PLANNING CONSULTATION RESPONSE

Application No	2026/0129
Proposal	Display of various illuminated and non-illuminated signage at the premises.
Address	Pentagon Chery, Plot 4, Claycliffe Road, Barugh, Barnsley, S75 1LR
Date of Consultation Reply	27/02/2026
Consultee	Pollution Control

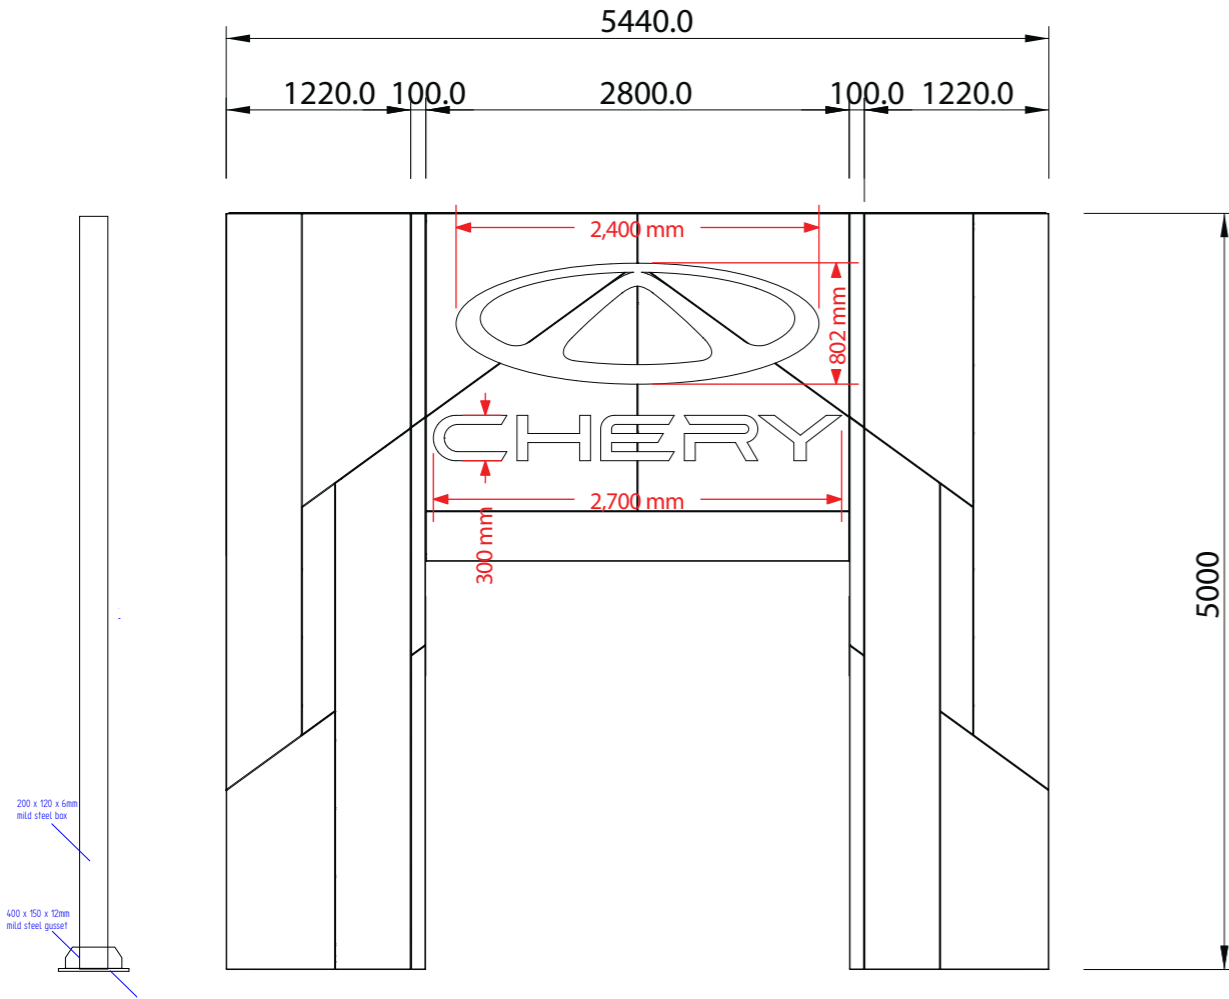
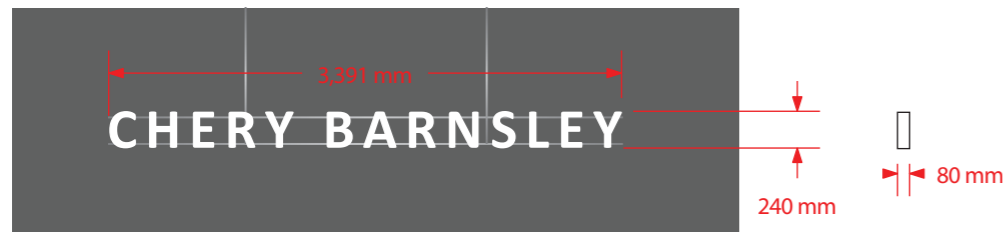
The advertisement displays described as “Facia Sign” on the application form, hereby permitted, shall not exceed the proposed maximum illuminance levels of 300 cd/m².

Sign E - 12x Chery Entrance Ribbons

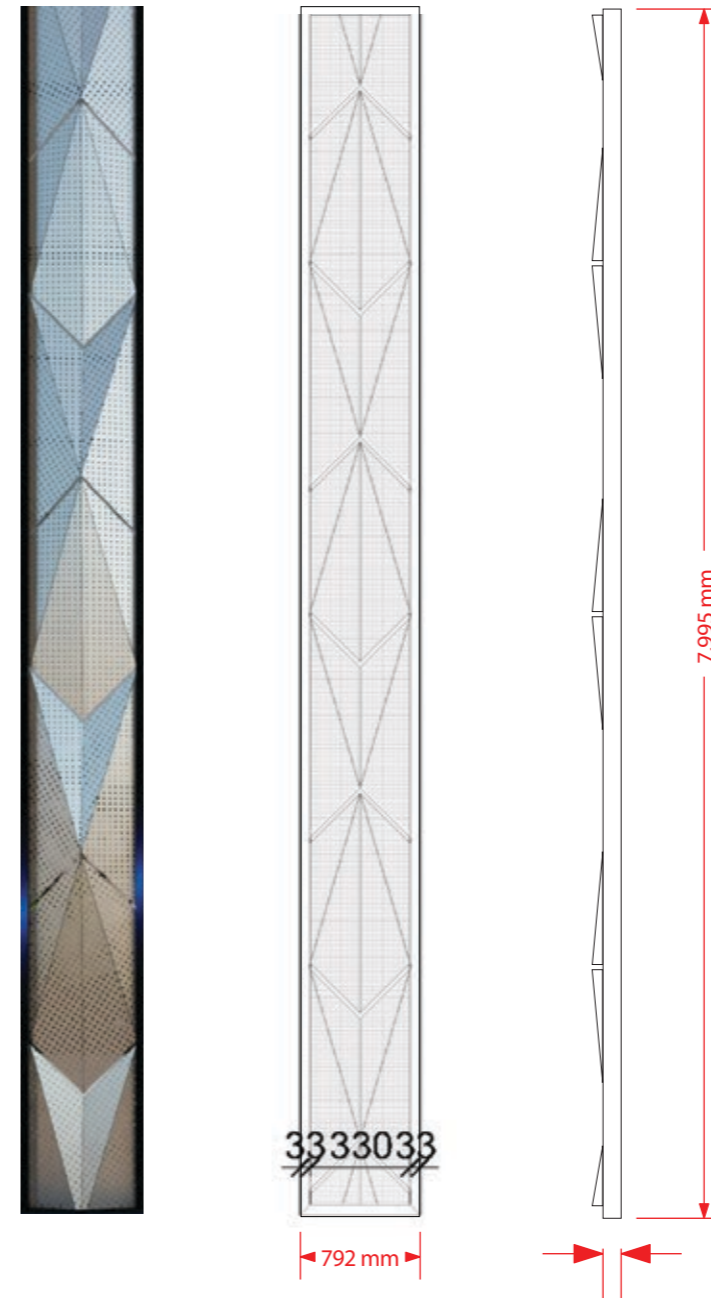
The advertisement displays described as “Other type” on the application form, hereby permitted, shall not exceed the proposed maximum illuminance levels of 280 cd/m².
